Response to Comments

Project Name: 163 RV Technical Review 1
 Project File Number: PA 23016
 Review Completion: October 2, 2023

Horton 453 Type I Ford E - Series Ambulance

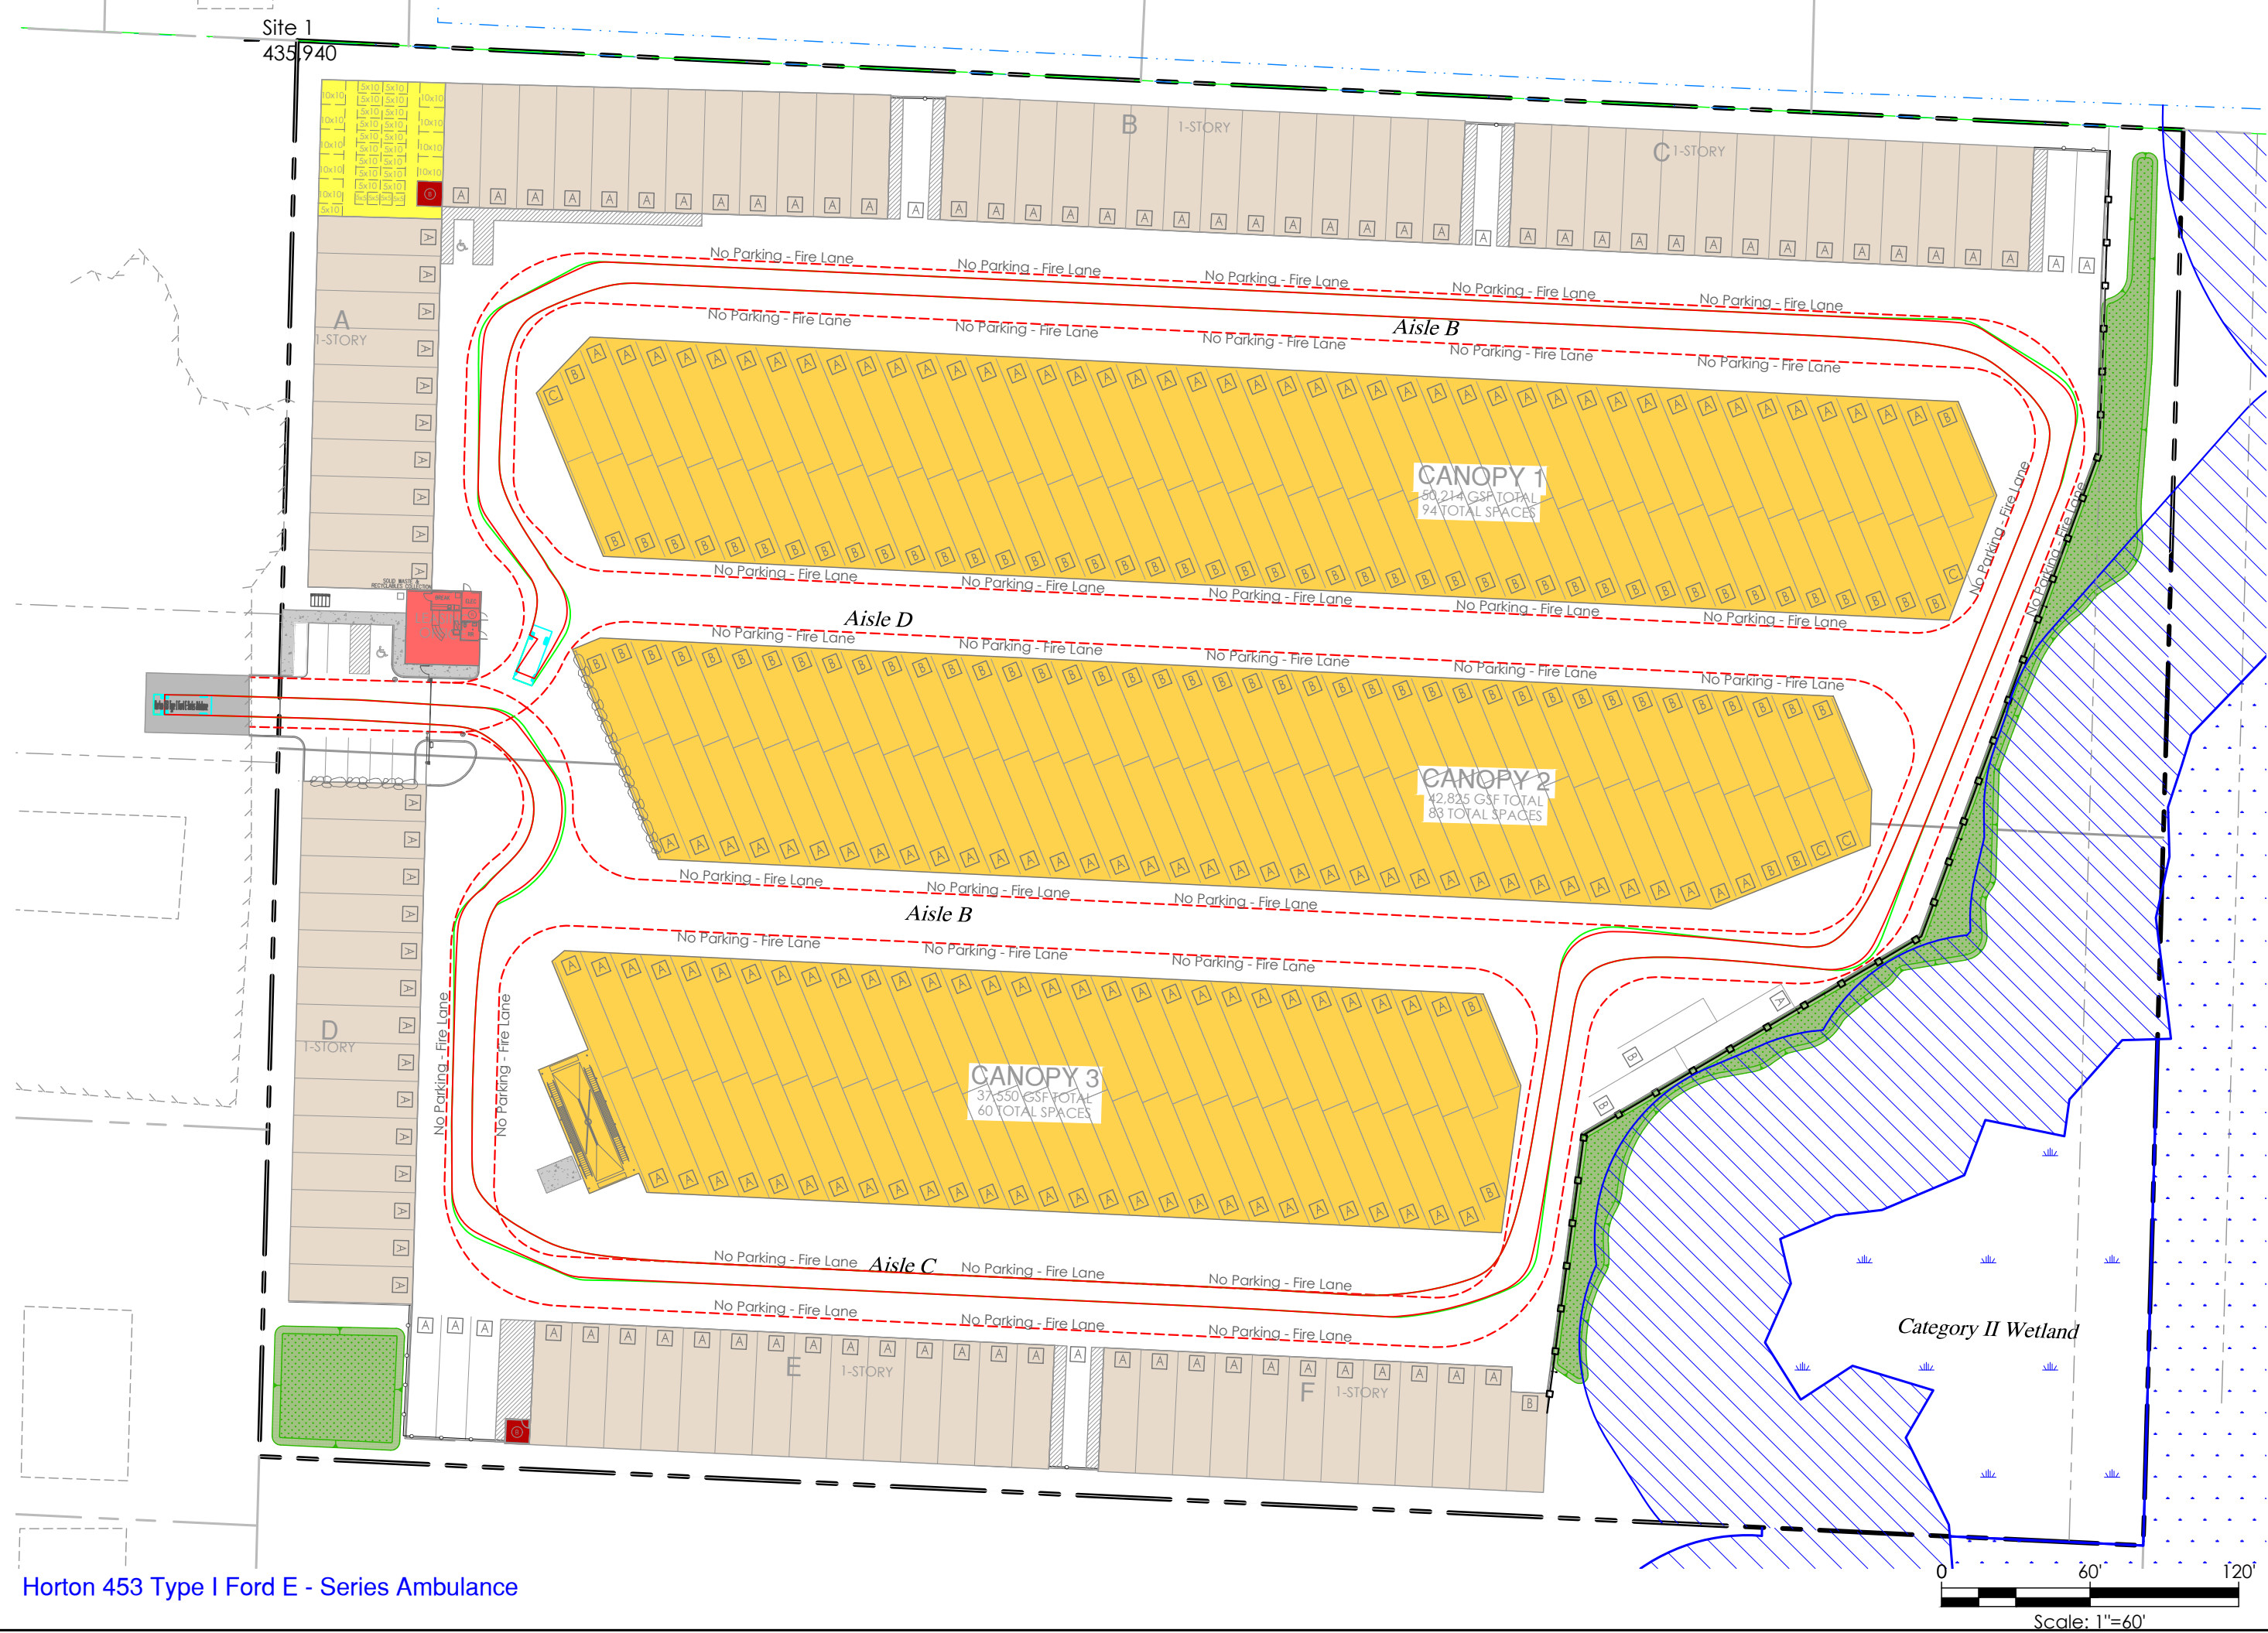
CITY COMMENTS	LAND TECH RESPONSE
<p>f. Provide the location for solid waste and recyclables collection. Contact Kristy Beedle, Solid Waste Supervisor, 360.36.8152 kbeedle@marysvillewa.gov, for enclosure size and design requirements.</p> <p>g. Provide an auto-turn exhibit demonstrating the Emergency Service vehicles, RV's, trucks and trailers can navigate through the site.</p>	<p>A Trash Service Area has been designated in Building A near the office. It will be enclosed in the building envelope and accessed via a roll-up door facing the customer parking</p> <p>C20 AutoTurn – Vehicle Tracking plan has been added to the plan set.</p>
<p>7. The landscape plan shall be amended, as follows:</p> <p>a. Street trees shall be required to be planted at a rate of 1 per 30 feet of frontage along the access drive from the proposed development to Smokey Point Boulevard, and comply with the following:</p> <p>i. Street trees shall be planted 5 to 8 ft. behind the sidewalk to create a continuous canopy.</p> <p>ii. Street trees shall meet the most recent ANSI standards for a 1 VV' caliper at the time of planting and shall be spaced to provide a continuous canopy coverage within 10-years.</p> <p>b. Add location of bike racks and provide detail. The bike racks will need to be</p>	<p>As per earlier arguments, this project cannot build the access road as requested. I am not sure the Street trees should be an element of Commercial Access Roads. In this case, this is primarily a Parking Lot Drive Aisle and should be subject to the Parking Lot Landscape Standards.</p> <p>Any trees at this time would significantly impact the existing uses and this applicant as no right to do that.</p> <p>A bike rack is shown just west of the Leasing Office and is set on a concrete pad.</p>
